**WEST SUSSEX COUNTY COUNCIL
STRATEGIC PLANNING CONSULTATION**

SUBJECT: LU/223/14/PL - Application under Regulation 3 of the Town and Country Planning General Regulations 1992 for erection of 8No houses and associated parking, hard and soft landscaping, on an existing parking court

Land north of, 52-67, Greenfields, Littlehampton, West Sussex, BN177JG

DRAWING NO. J48.22/02
Scale: 1:200 at A3
Added to by: NL
03/02/2014

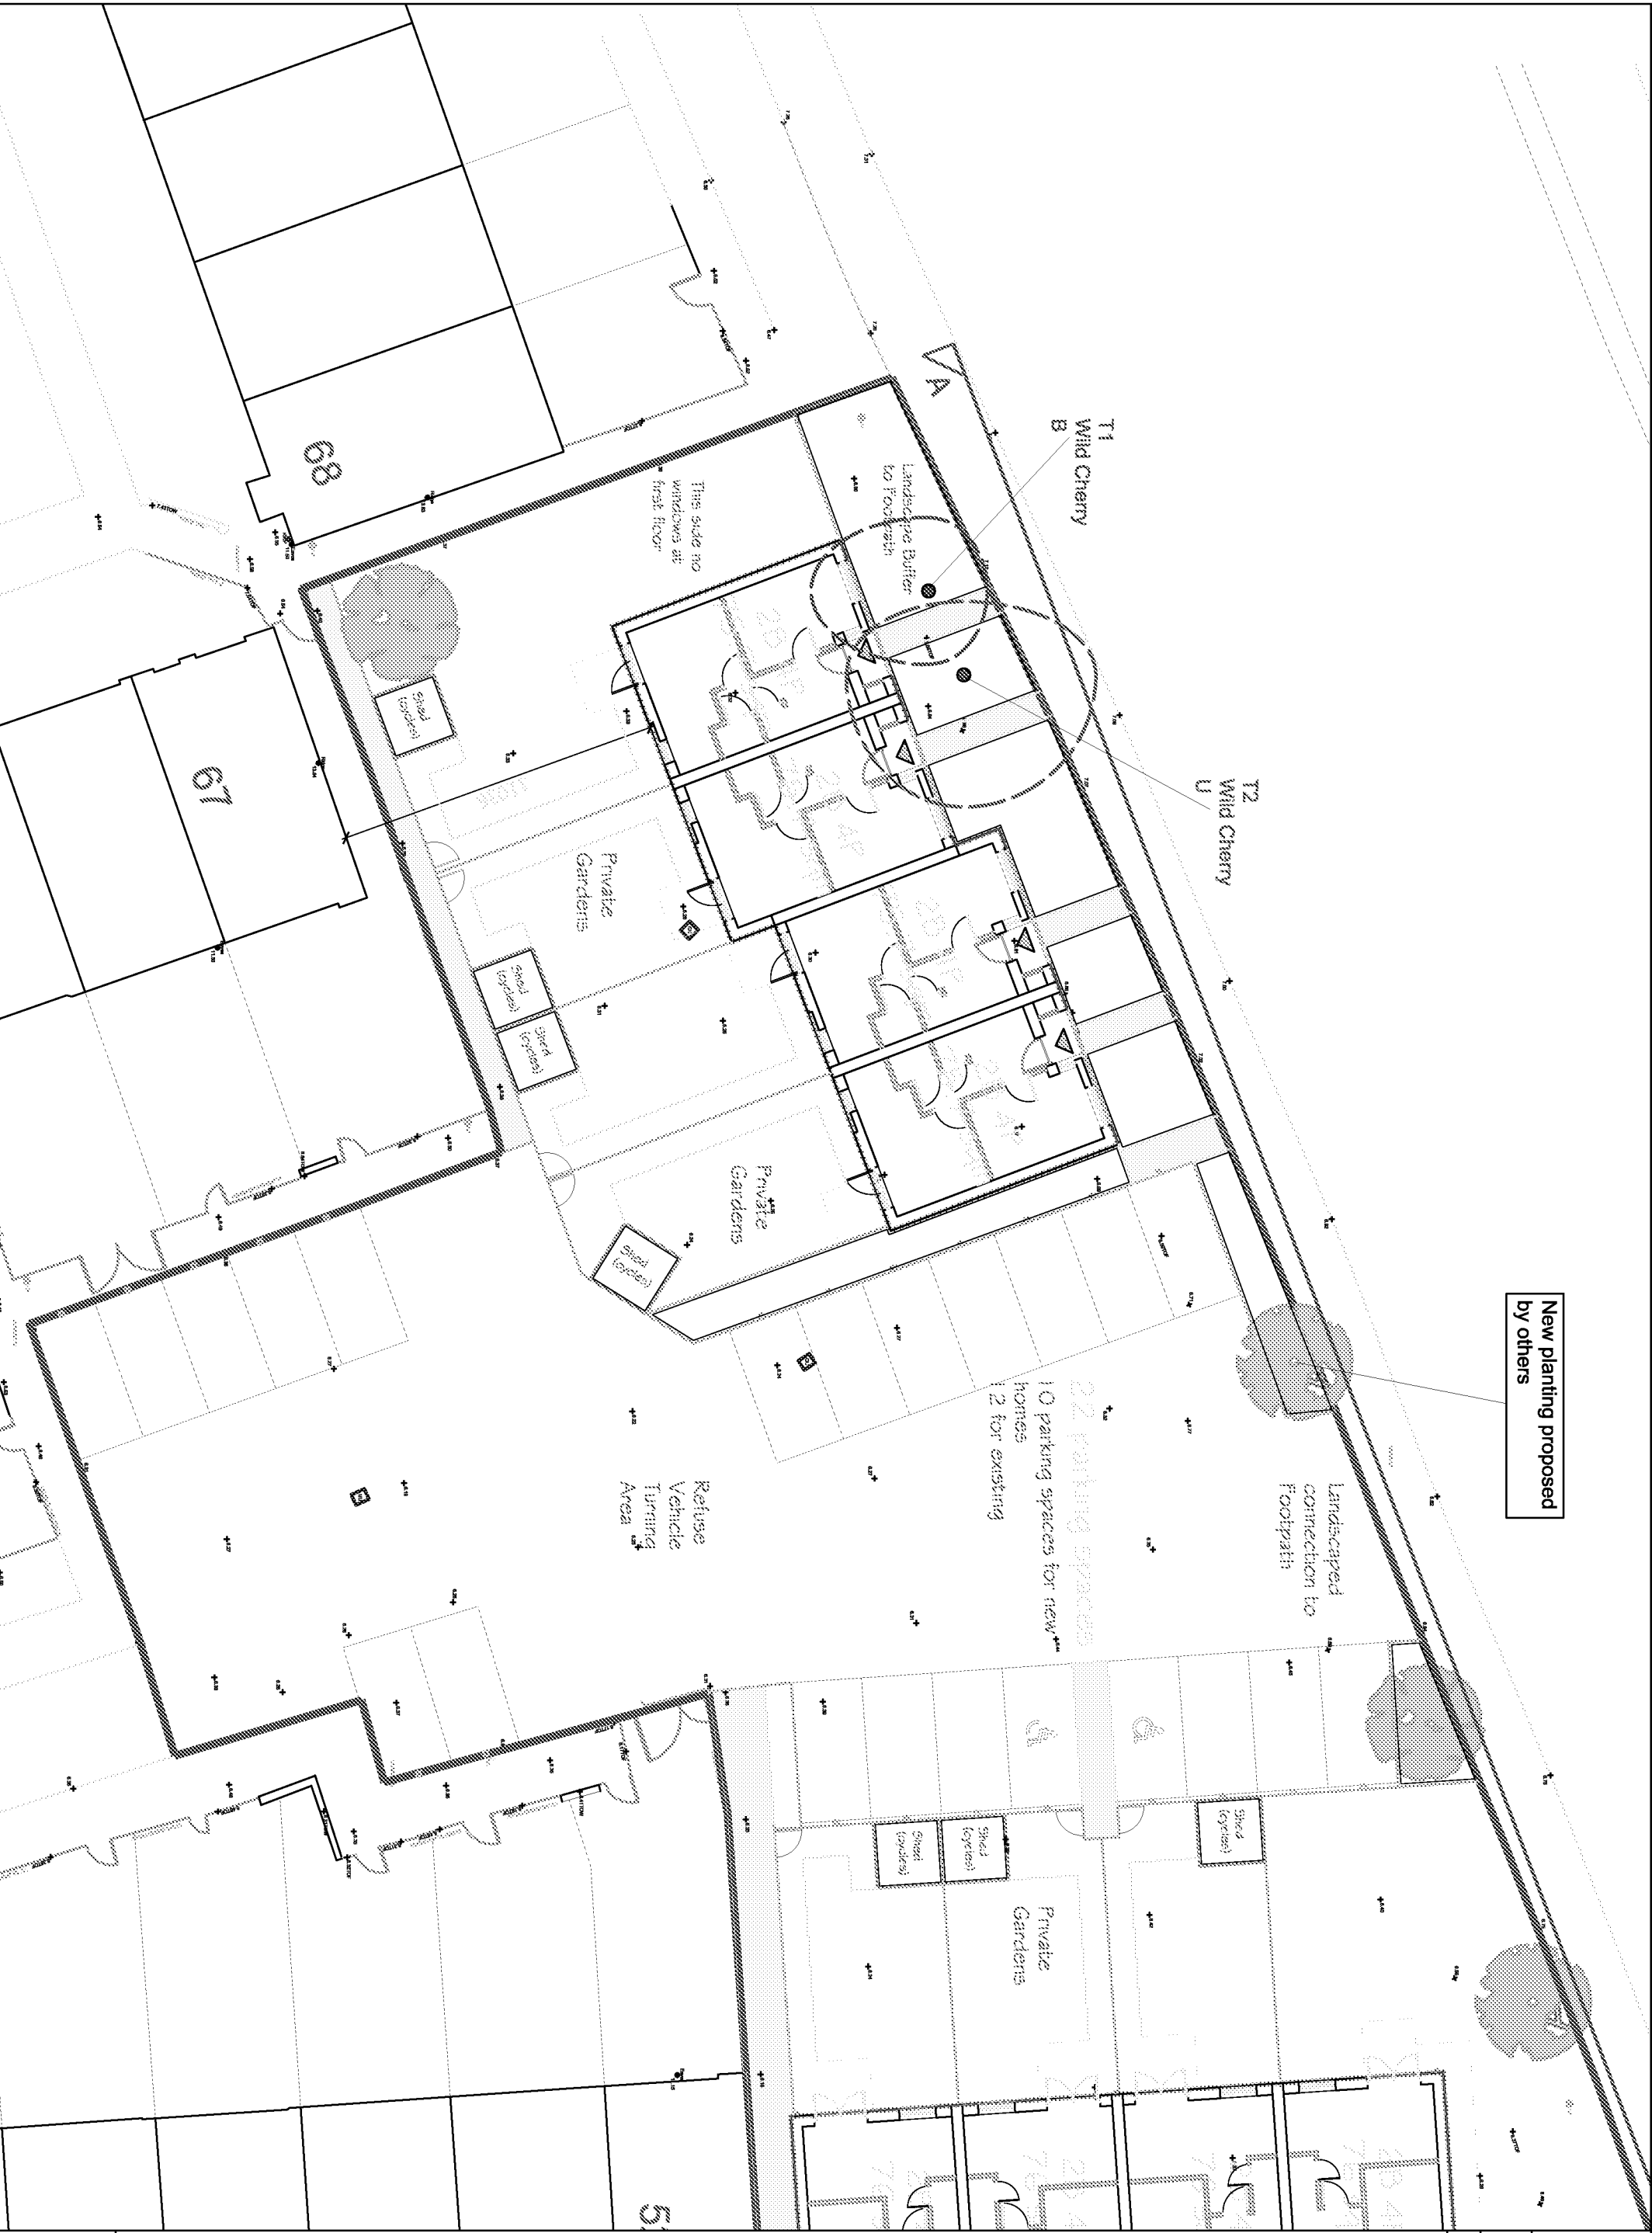
Considered against the WSCC Parking Demand Calculator, the developments parking allocation is considered acceptable. Visitor parking would be short term and unlikely to generate any significant highway safety issue, therefore an objection on the basis of a short falling on parking would not be raised. The Planning Authority may wish to consider the implications of this proposal upon on-street parking.

Refuse collection will take place from within the site. The waste collection authority should be consulted to obtain their views on the suitability of this arrangement. The Technical Plan shows a swept path analysis showing how a larger vehicle including a refuse vehicle can safely turn within the site.

No part of the development shall be first occupied until the car parking has been constructed in accordance with the approved site plan. These spaces shall thereafter be retained at all times for their designated purpose.
